Recommendation Report for Planning Permission

REF NO: **A/84/12/**

LOCATION: Foschini's Nursery
 Hangleton Lane
 Ferring

PROPOSAL: New house replacing mobile home. (Resubmission following A/129/11).
 Departure from the Development Plan.

tp675/13a

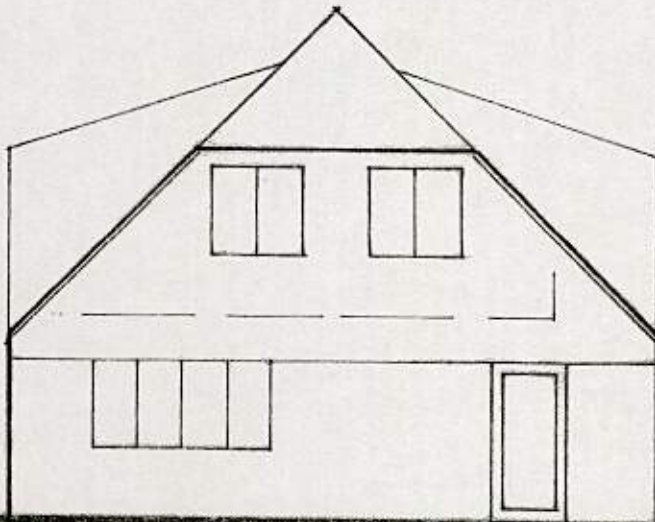
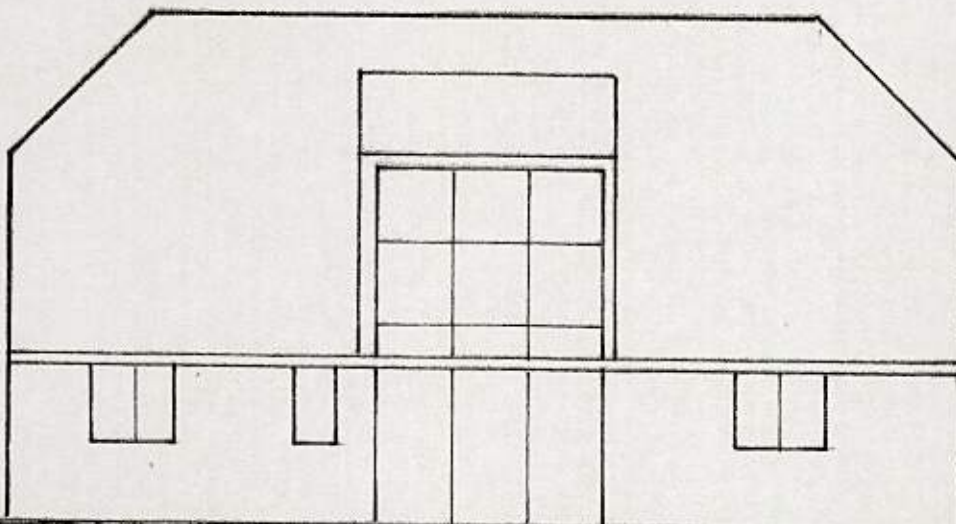
This application is a resubmission of A/129/11 which was refused. The red edge to the application site has not been reduced and is as previously submitted and refused under this reference and the footprint is identical. The roof of the dwelling has been reduced in span and hipped and reduced in height, but the dwelling is still two storey and the amended plans do not reduce the footprint or the amount of development significantly or provide any justification for a dwelling of this size. The Design and Access Statement has not been altered. It refers to the applicant, Mr Gian Luca's requirement for a 4 bedroom house on the site to provide a separate bedroom for each of his 3 children. When the Certificate application A/94/09/CLE was submitted it was stated that Gian Foschini's father, resided in the mobile home in February 1995. In December 1995 he moved into Carol Anne House and his son (the current applicant) continued to reside in the portacabin until October 1997. From October 1997 the cabin was lived in by Gian Foschini's friend Mark Hampshire who had no plans to vacate. The applicant had vacated the cabin to reside in rented accommodation elsewhere in October 1997. In 2006 he was living in Dovecot mobile home on Foschinis Nursery with his wife and 2 children. There is no evidence stating who the current occupier of the cabin is or whether the applicant still has an alternative home on the Nursery site.

- 1 The proposed replacement two-storey dwelling, by reason of its permanence, scale, massing and height, would be harmful towards the visual amenities rural character and appearance of the surrounding area, in conflict with policies GEN3 and GEN7 of the Arun District Local Plan.
- 2 There is no justification for the increase in plot size which would cover twice the size of the existing curtilage and would represent an unacceptable encroachment into the surroundings, consolidating residential development in a rural location, in conflict with Arun District Local Plan Policy GEN3.

revision
tp675/10a

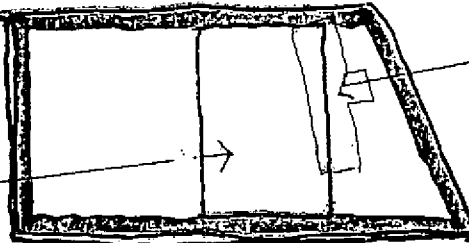
The site is located outside of the built-up area where the principle of development is unacceptable, unless it qualifies as an exception. When the application for a Certificate of Lawful Use for the site for a residential unit was submitted, the area of the curtilage was approximately 143 square metres, the caravan sited on it housing one bedroom. The current application has increased the size of the plot to approximately 360 square metres whilst the proposed dwelling, a two-storey house, will provide four bedrooms. The proposal is considered to be an unacceptable intensification given its rural location and the increase in both dwelling and plot size.
